From: Liz Annalls [REDACTED]
Sent: 02 December 2019 11:35
To: Planning.Responses <Planning.Responses@arun.gov.uk>
Subject: RE: Planning Consultation on: A/166/19/RES

App No: A/166/19/RES

Address: The Laurels Dappers Lane Angmering BN16 4EN

Proposal: Approval of Reserved Matters following Outline consent (Reference A/74/18/OUT) relating to the layout, scale, appearance and landscaping for the erection of 9no two storey dwellings consisting of 2no two bedroom dwellings, 3no three bedroom dwellings and 4no four bedroom dwellings - This is a Departure from the Development Plan

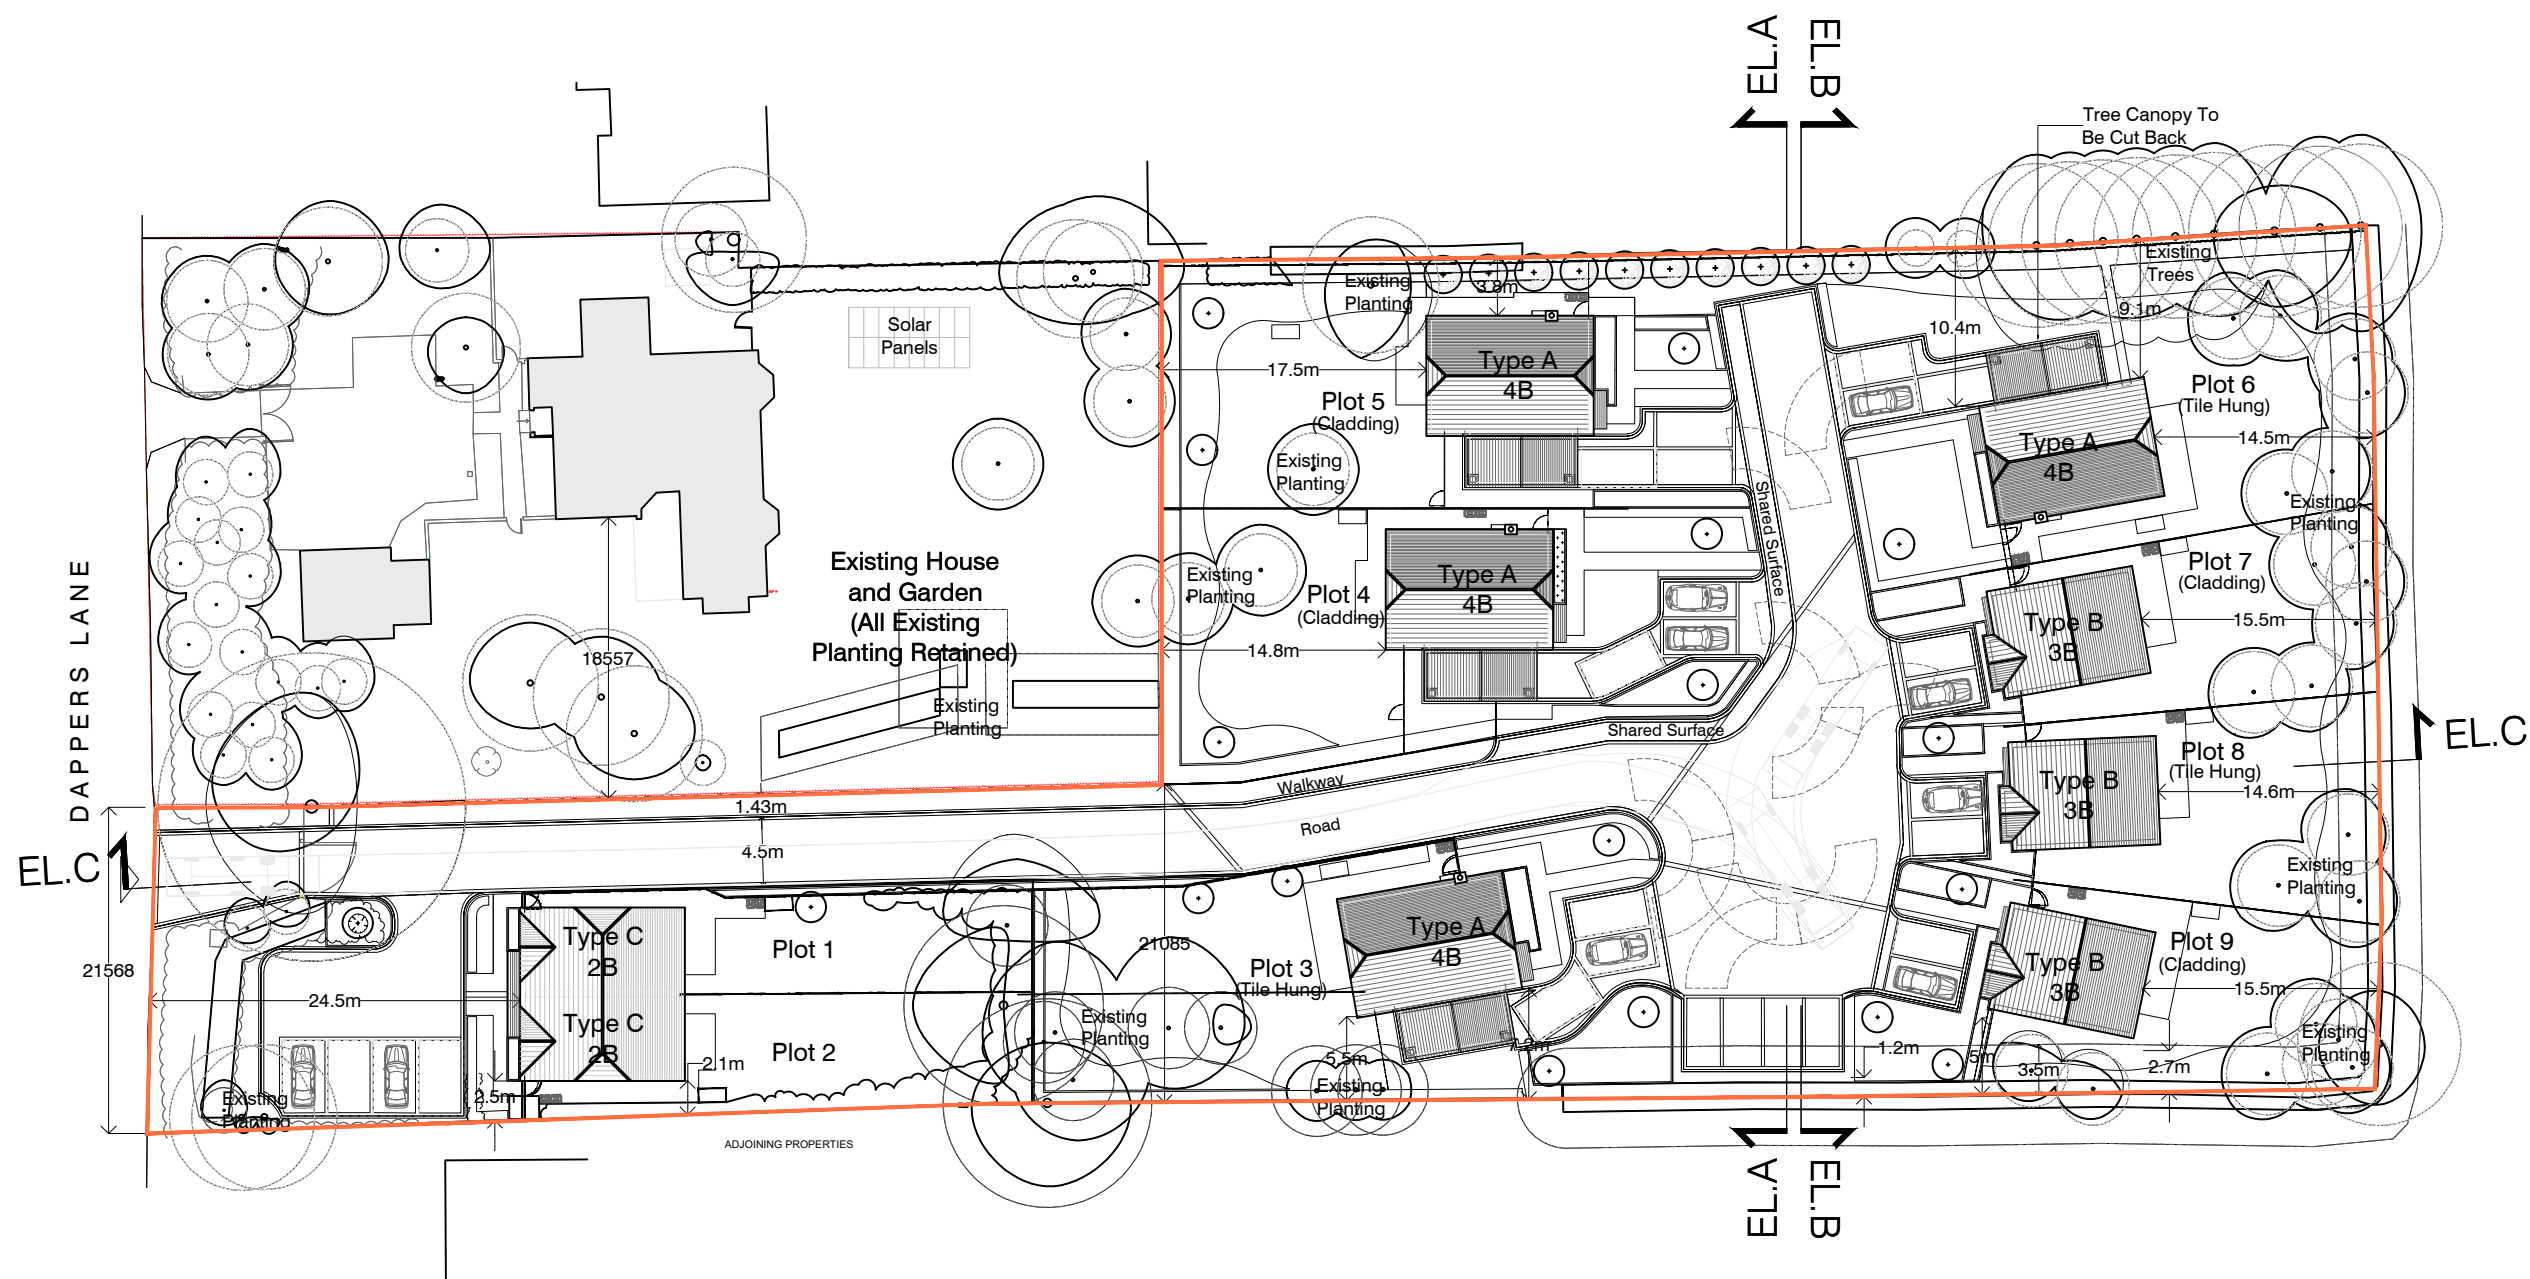
The current plans show that the main house and garage are being retained. Due to the high potential for bats within these buildings, if plans change and any works are required to these buildings then further bat surveys would be required.

The hedgerows on site are used by bats for commuting and foraging and will need to be retained and enhanced for bats. This will include having a buffer strip around the hedgerows and during construction fencing should be used to ensure this area is undisturbed. Any gaps should also be filled in using native hedge species to improve connectivity. Where any hedge is to be removed at detailed within the survey, new hedgerow should be planted. Conditions should be used to ensure this.

We require that a bat brick is integrated into the buildings onsite facing south/south westerly positioned 3-5m above ground.

We would like a number of bird boxes to be installed on the new buildings / and or trees within the site.
